FRASERS PUTNEY STAGE 1 PHASE 1

ACCESS REVIEW

Morris-Goding Accessibility Consulting

17th March 2011

Drawing Title	APARTMENT PLANS - TYPICAL
Drawing Number	A-PA-FP-A5
Revision	01
Date	2011-12-12
Drawn	AG
Scale	1:100@A1
North

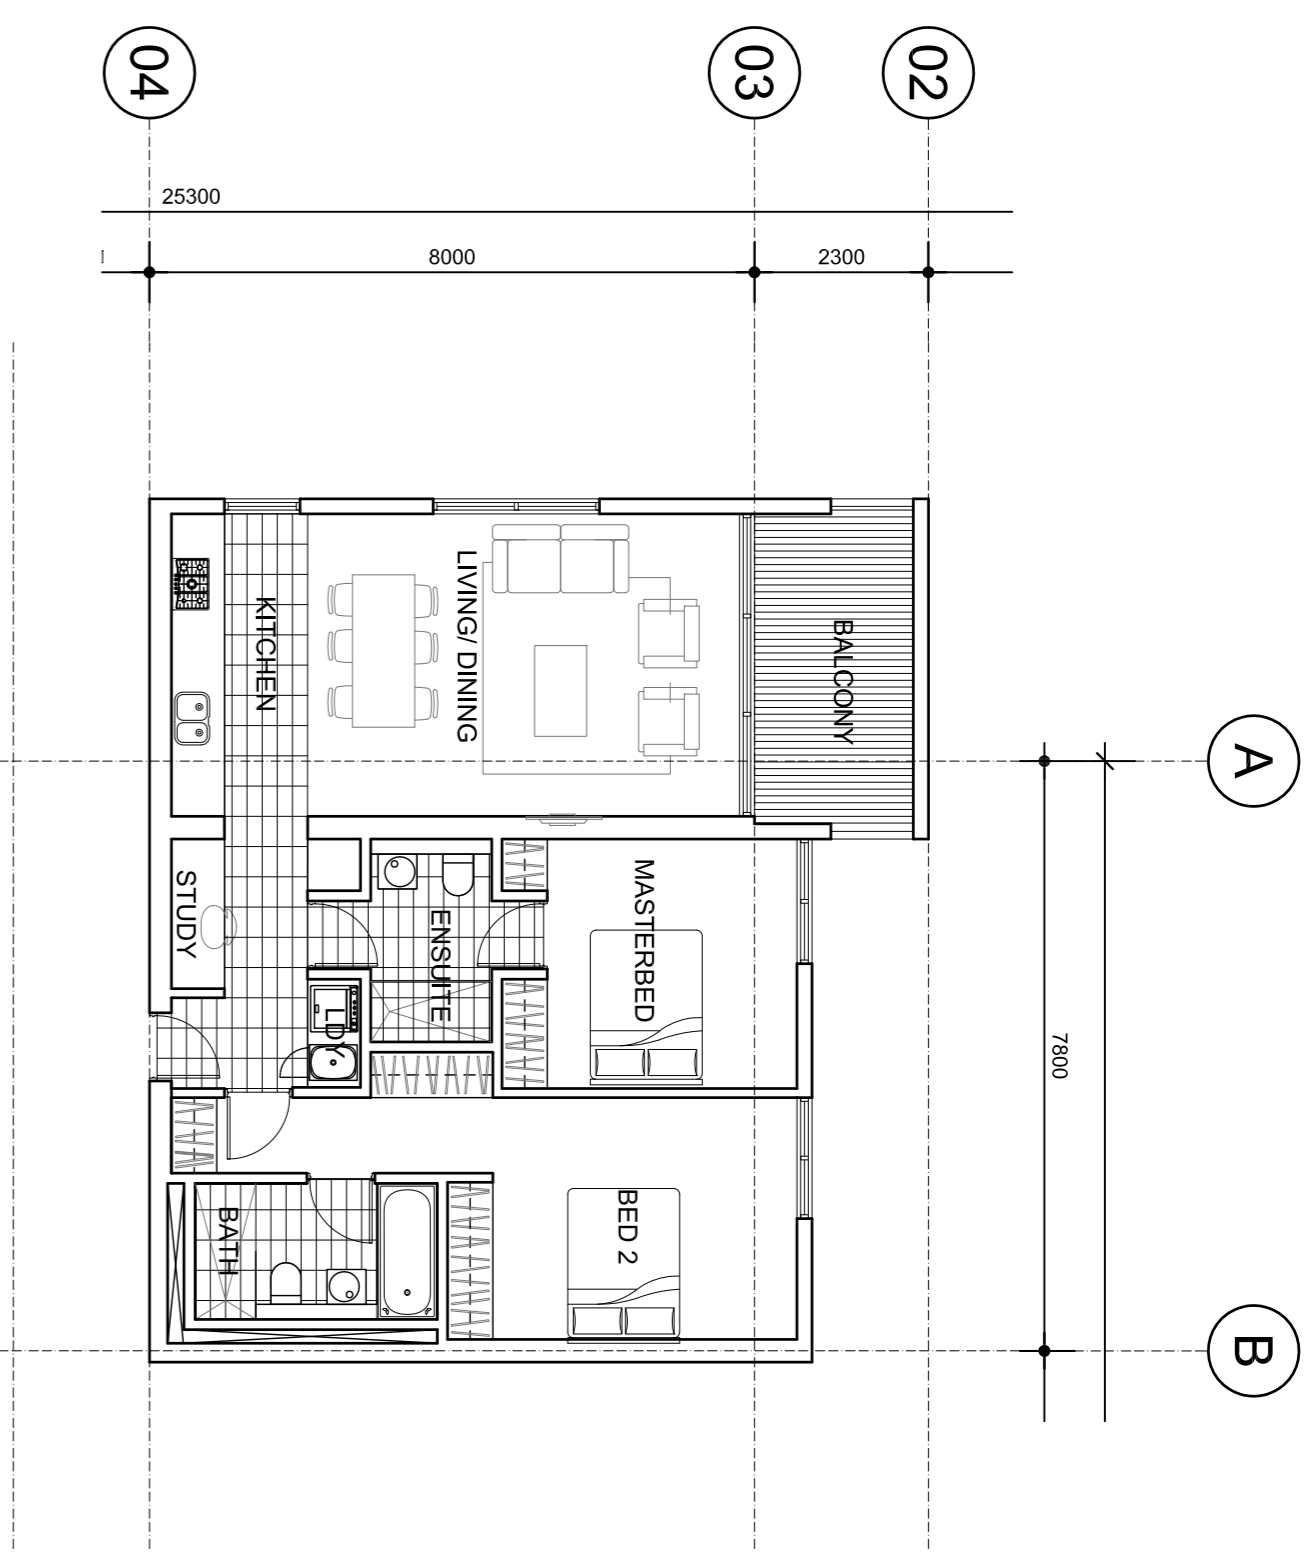
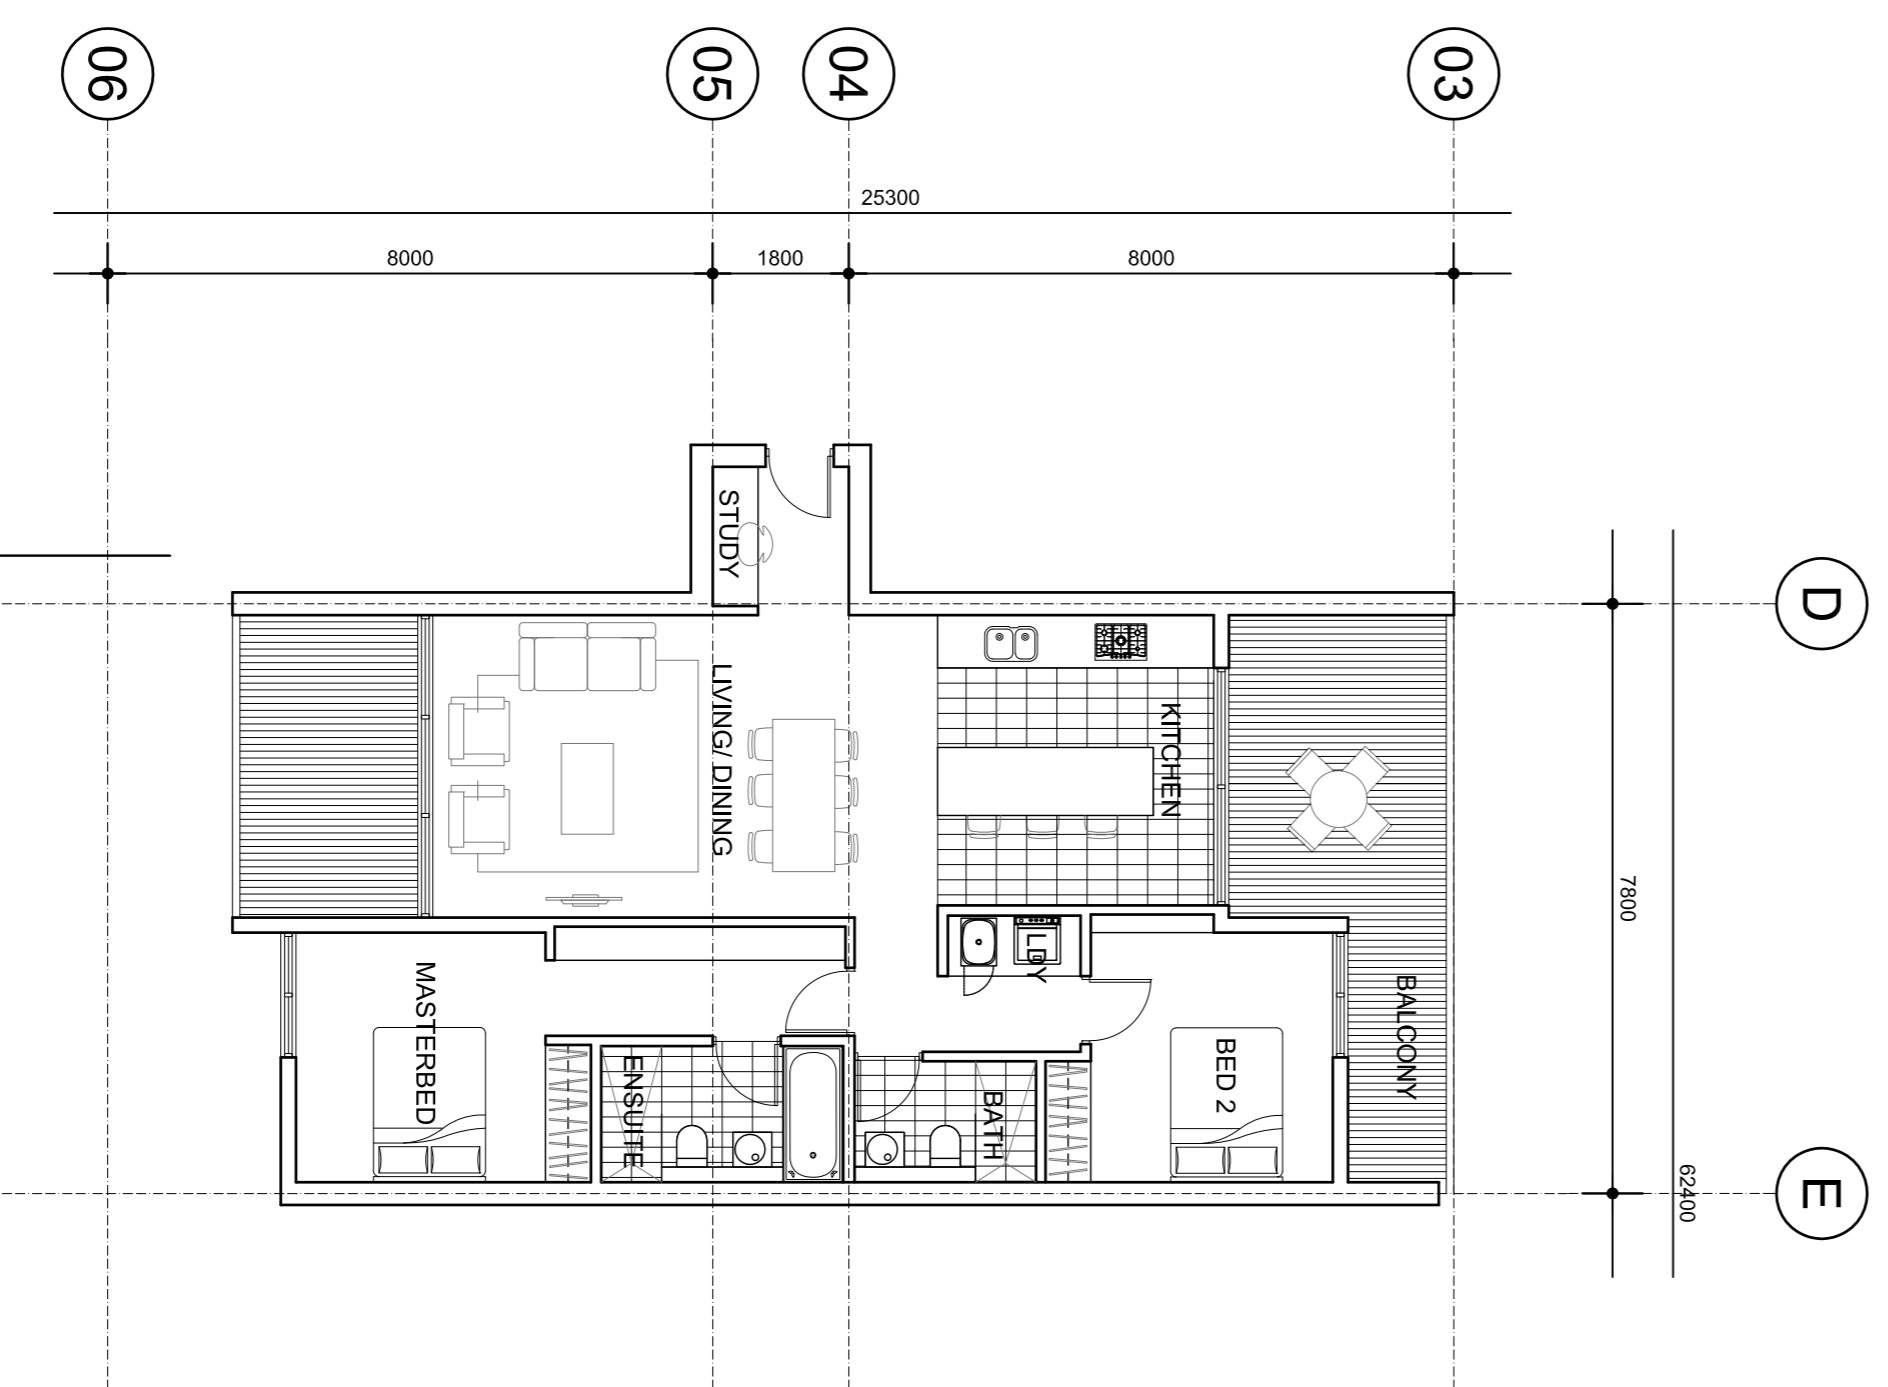
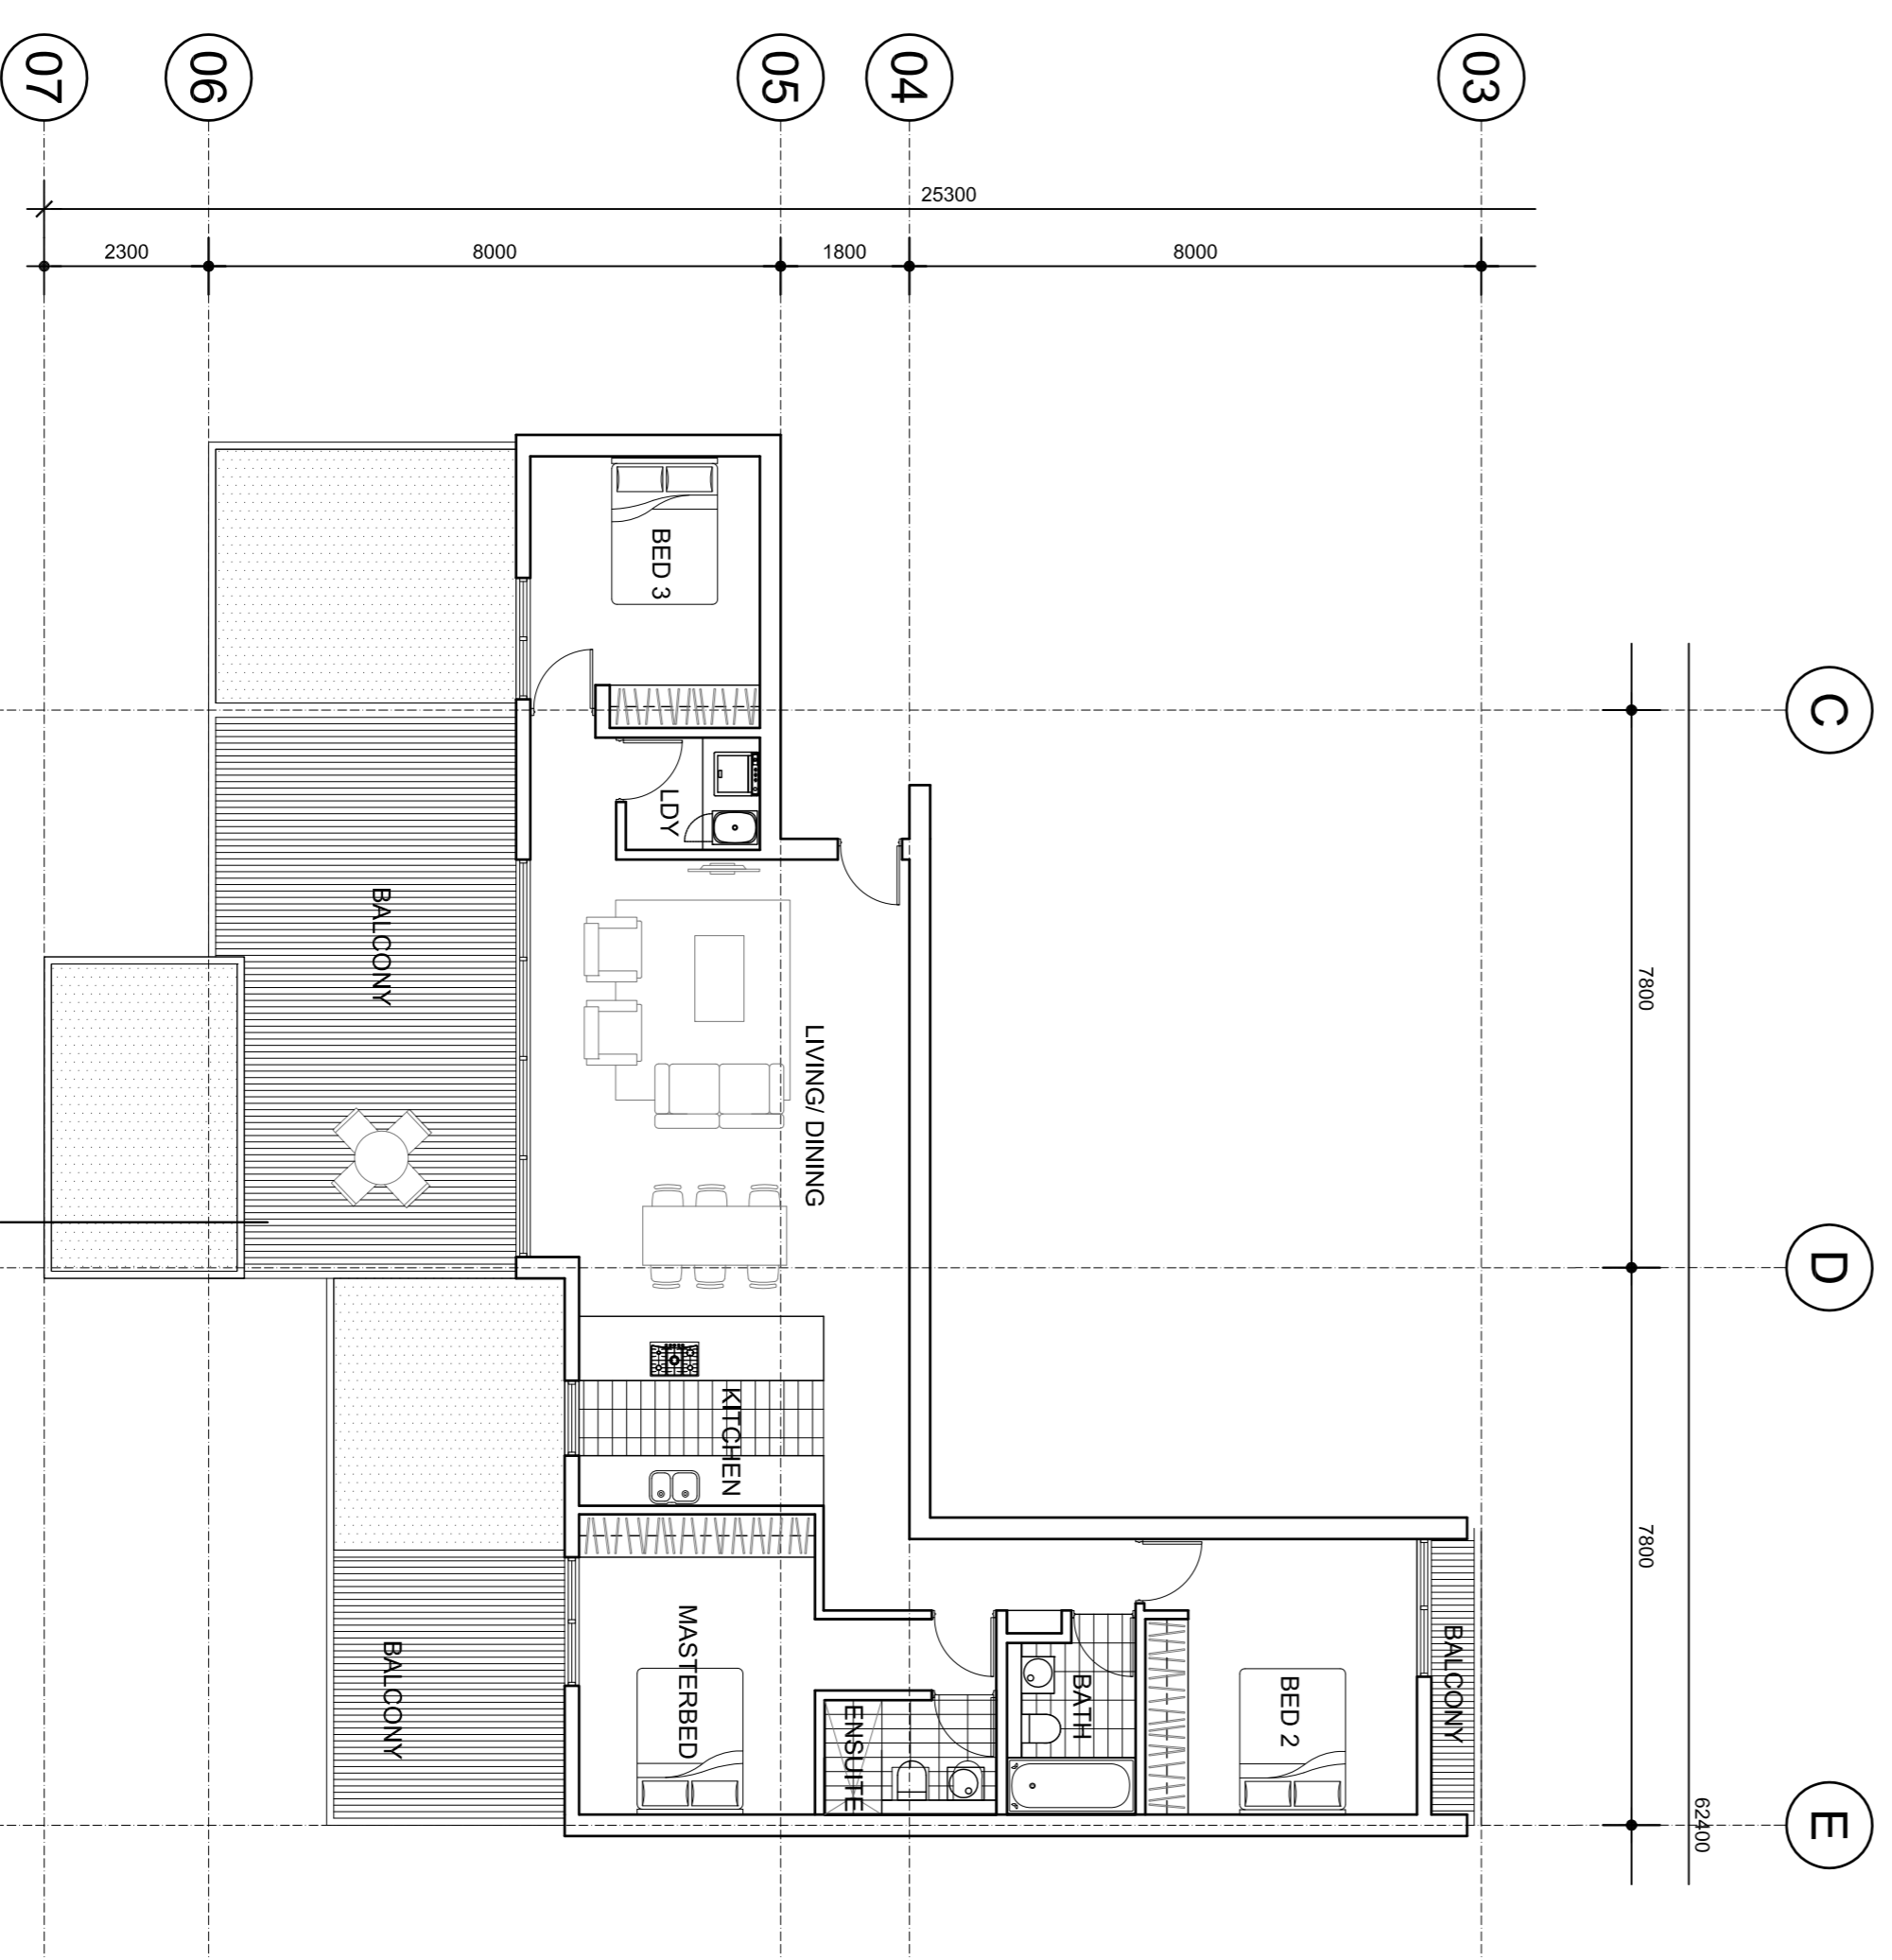
At this stage, the drawings have not designated the proposed adaptable units.

At this stage of the development it is recommended that the following measures are implemented in the design layout of each adaptable unit. These measures will ensure the correct circulation areas are provided for a person using a wheelchair, compliant with AS14281:2009 and AS4299.

- (i) Provide drawings of the adaptable unit in its pre and post adaptation stage.
- (ii) The entry door to have 850mm clear width (920mm door leaf) and provide a 510-530mm latch side clearance on the external and internal side of the door.
- (iii) Internal doors (main bedroom, bathroom, laundry) require 820mm clear width with provision for 515mm - 565mm latch side clearance.
- (iv) Provisions for internal door circulation areas to comply with AS1428.1:2009.
- (v) The bedroom requires internal dimensions of 3.6m x 3.6m, outside the robe area.

- (vi) Bathroom (shower, toilet, wash basin) to comply with circulation area requirements of AS1428.1:2009 ie. provide an area of 2300mm x 1900mm around the WC pan. The wash basin to sit outside this area, and if needed only encroach into this area by 100mm (max). The shower area requires 2500mm x 1600mm.
- (vii) The kitchen is required to have a clearance of 1550mm between base cabinets Provide work bench space (800mm min. width) adjacent to refrigerator, cook top, oven & sink which could be replaceable/adjustable in height.
- (viii) The living area should have clear area of 2250mm minimum diameter after the furniture has been placed will satisfy this requirement.
- (ix) The laundry area to have a circulation area in front of the laundry appliances of 1550mm in diameter
